Date: 7th February 2019
Our ref: CPD: 11102019
Your ref: 6/2018/3292/MAJ
Direct No: 01707 355225
E-mail: gerry.brophy@herts.pnn.police.

Re: Land adjacent 45 Broadwater Road

Thank you for sight of this application on which I have commented at an earlier date.

SITE PLAN - AS PROPOSED

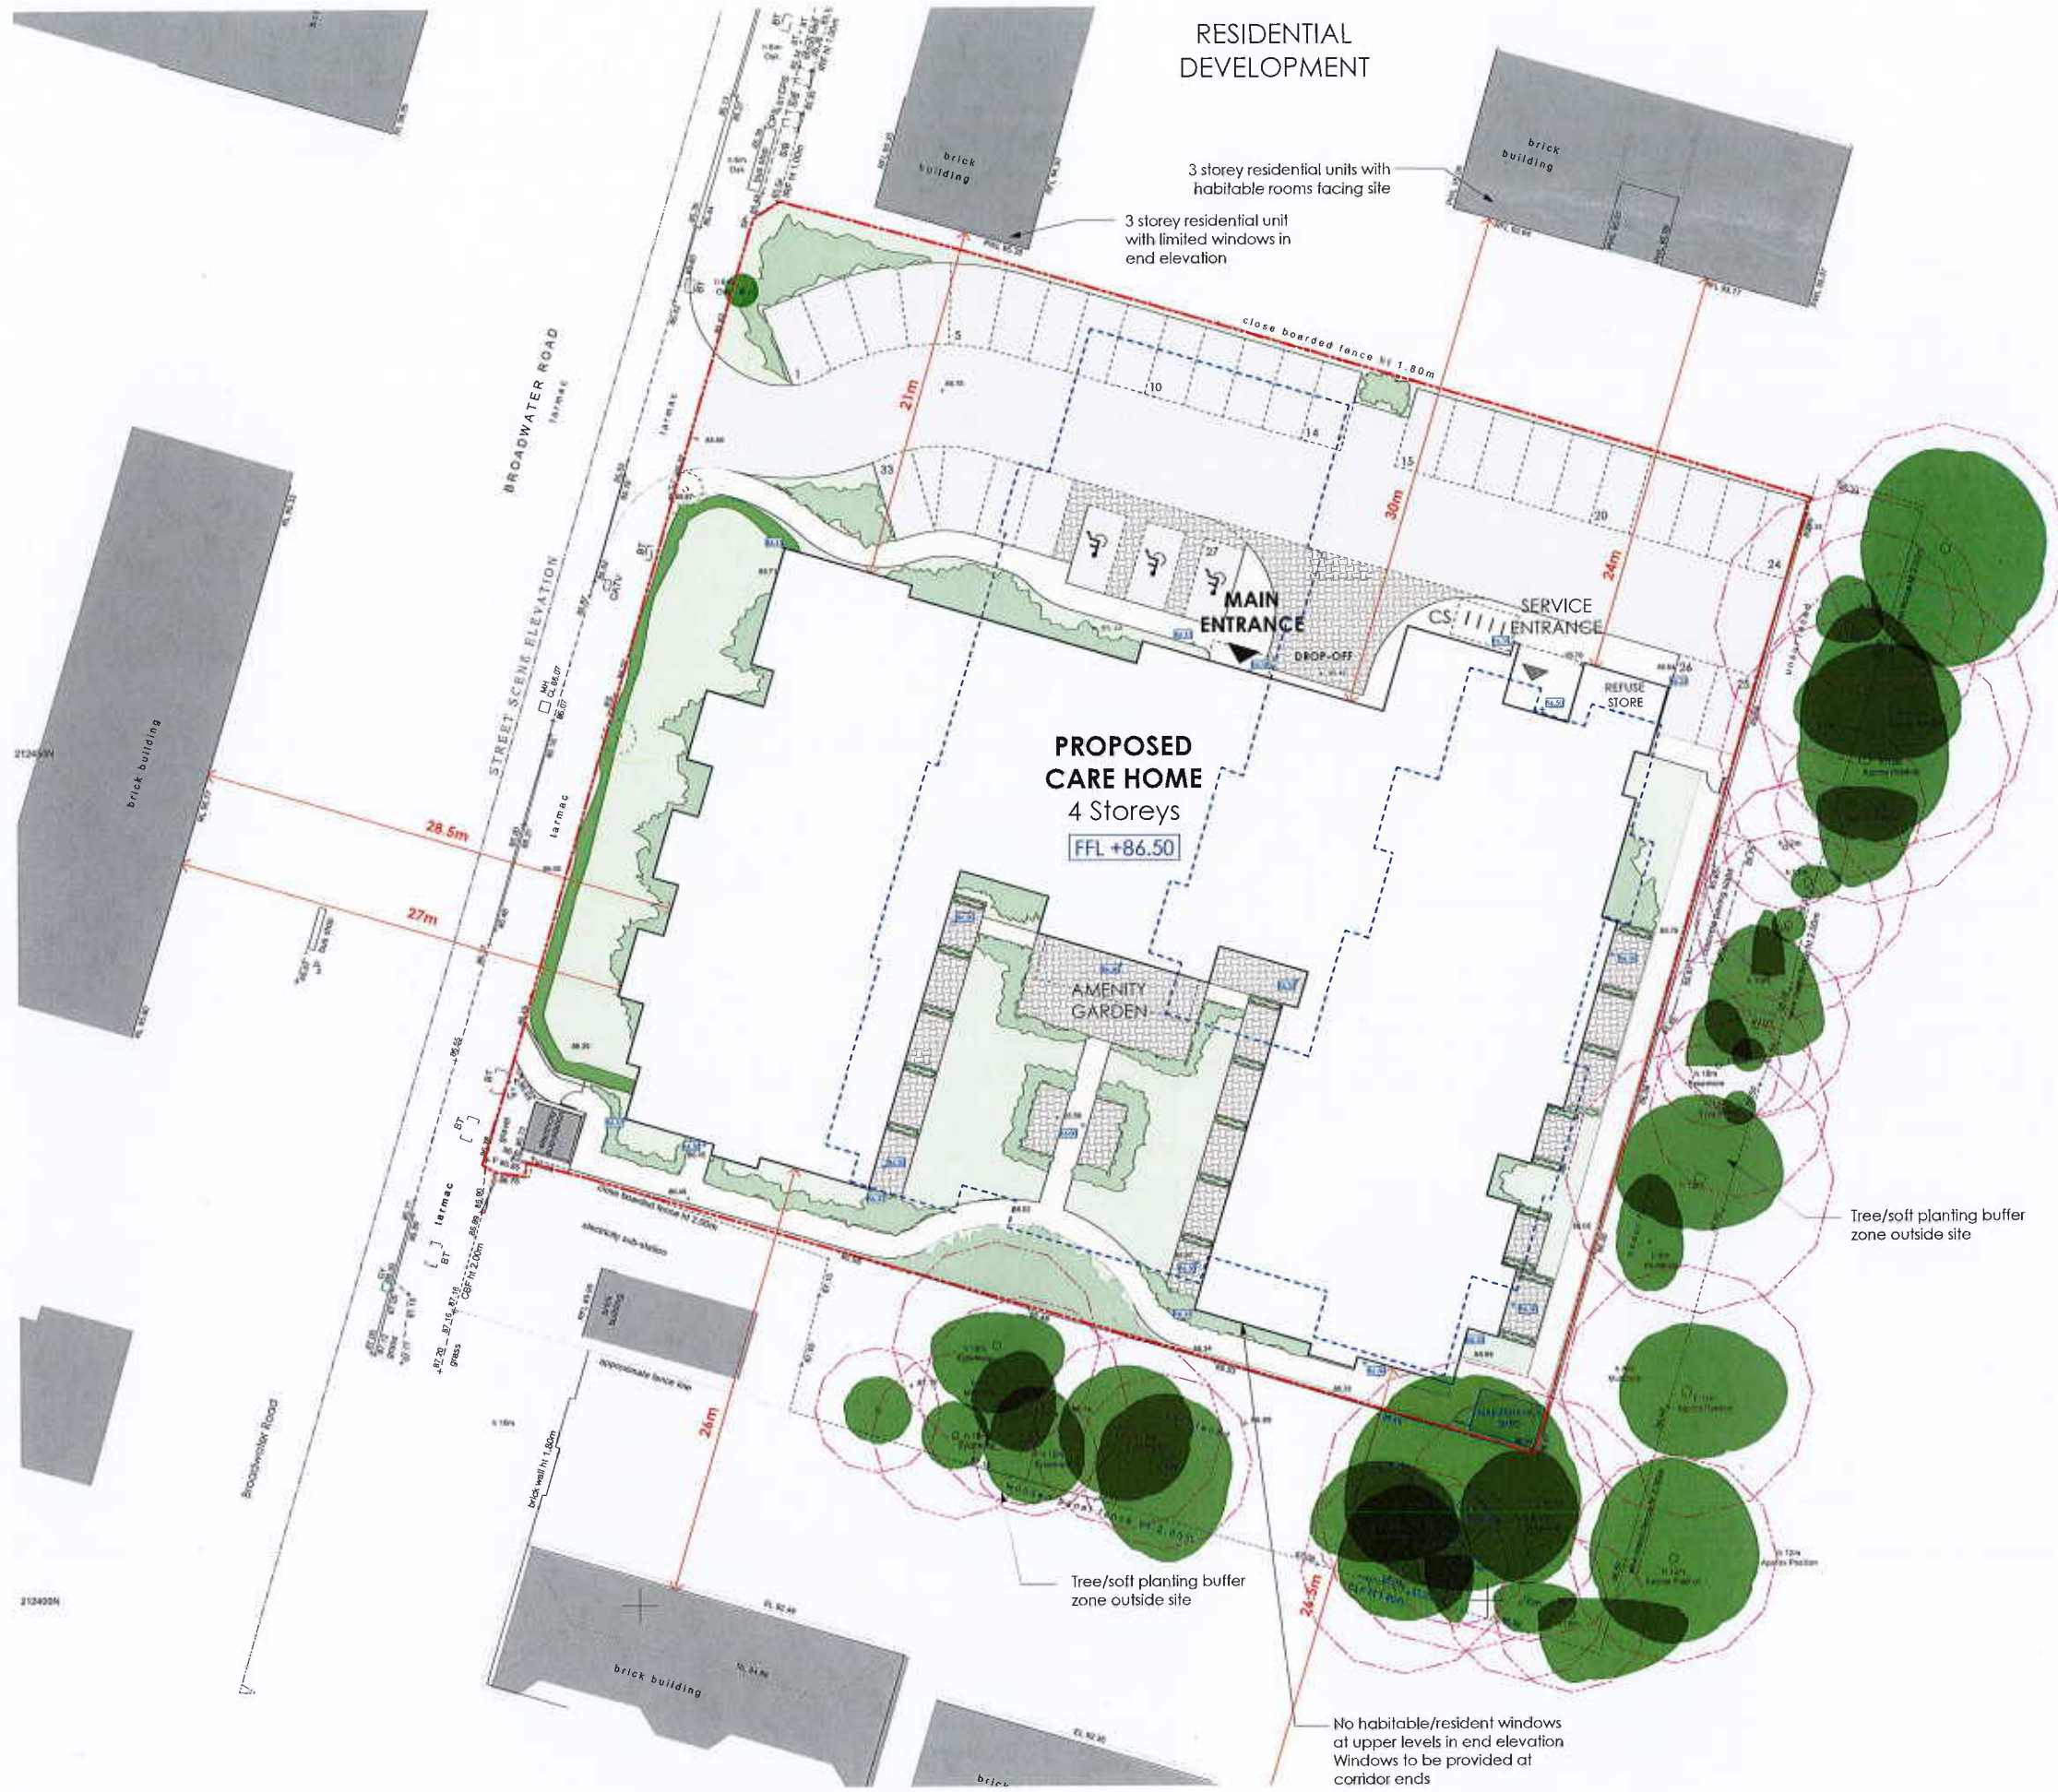
The offered design is good but has two panels of low height (1.1M), which should be replaced with higher 1.8M panels. The low fence panels occur in the NE and SW corners, where the fence returns to the building line. Without 1.8M panels, it is too easy to gain access to the rear of the building.

As stated earlier, there needs to be an element of exterior lighting to allow for safe use by the occupants, and to act as a criminal deterrent. The lighting should be of a uniform nature and be dusk to dawn controlled.

Building mounted and column lighting is vastly superior to 'Bollards', which have an unnatural 'up-lighting' effect that can be unsettling to some people.

I would recommend that CCTV should be provided to cover the perimeter of the building and also the main entrance.
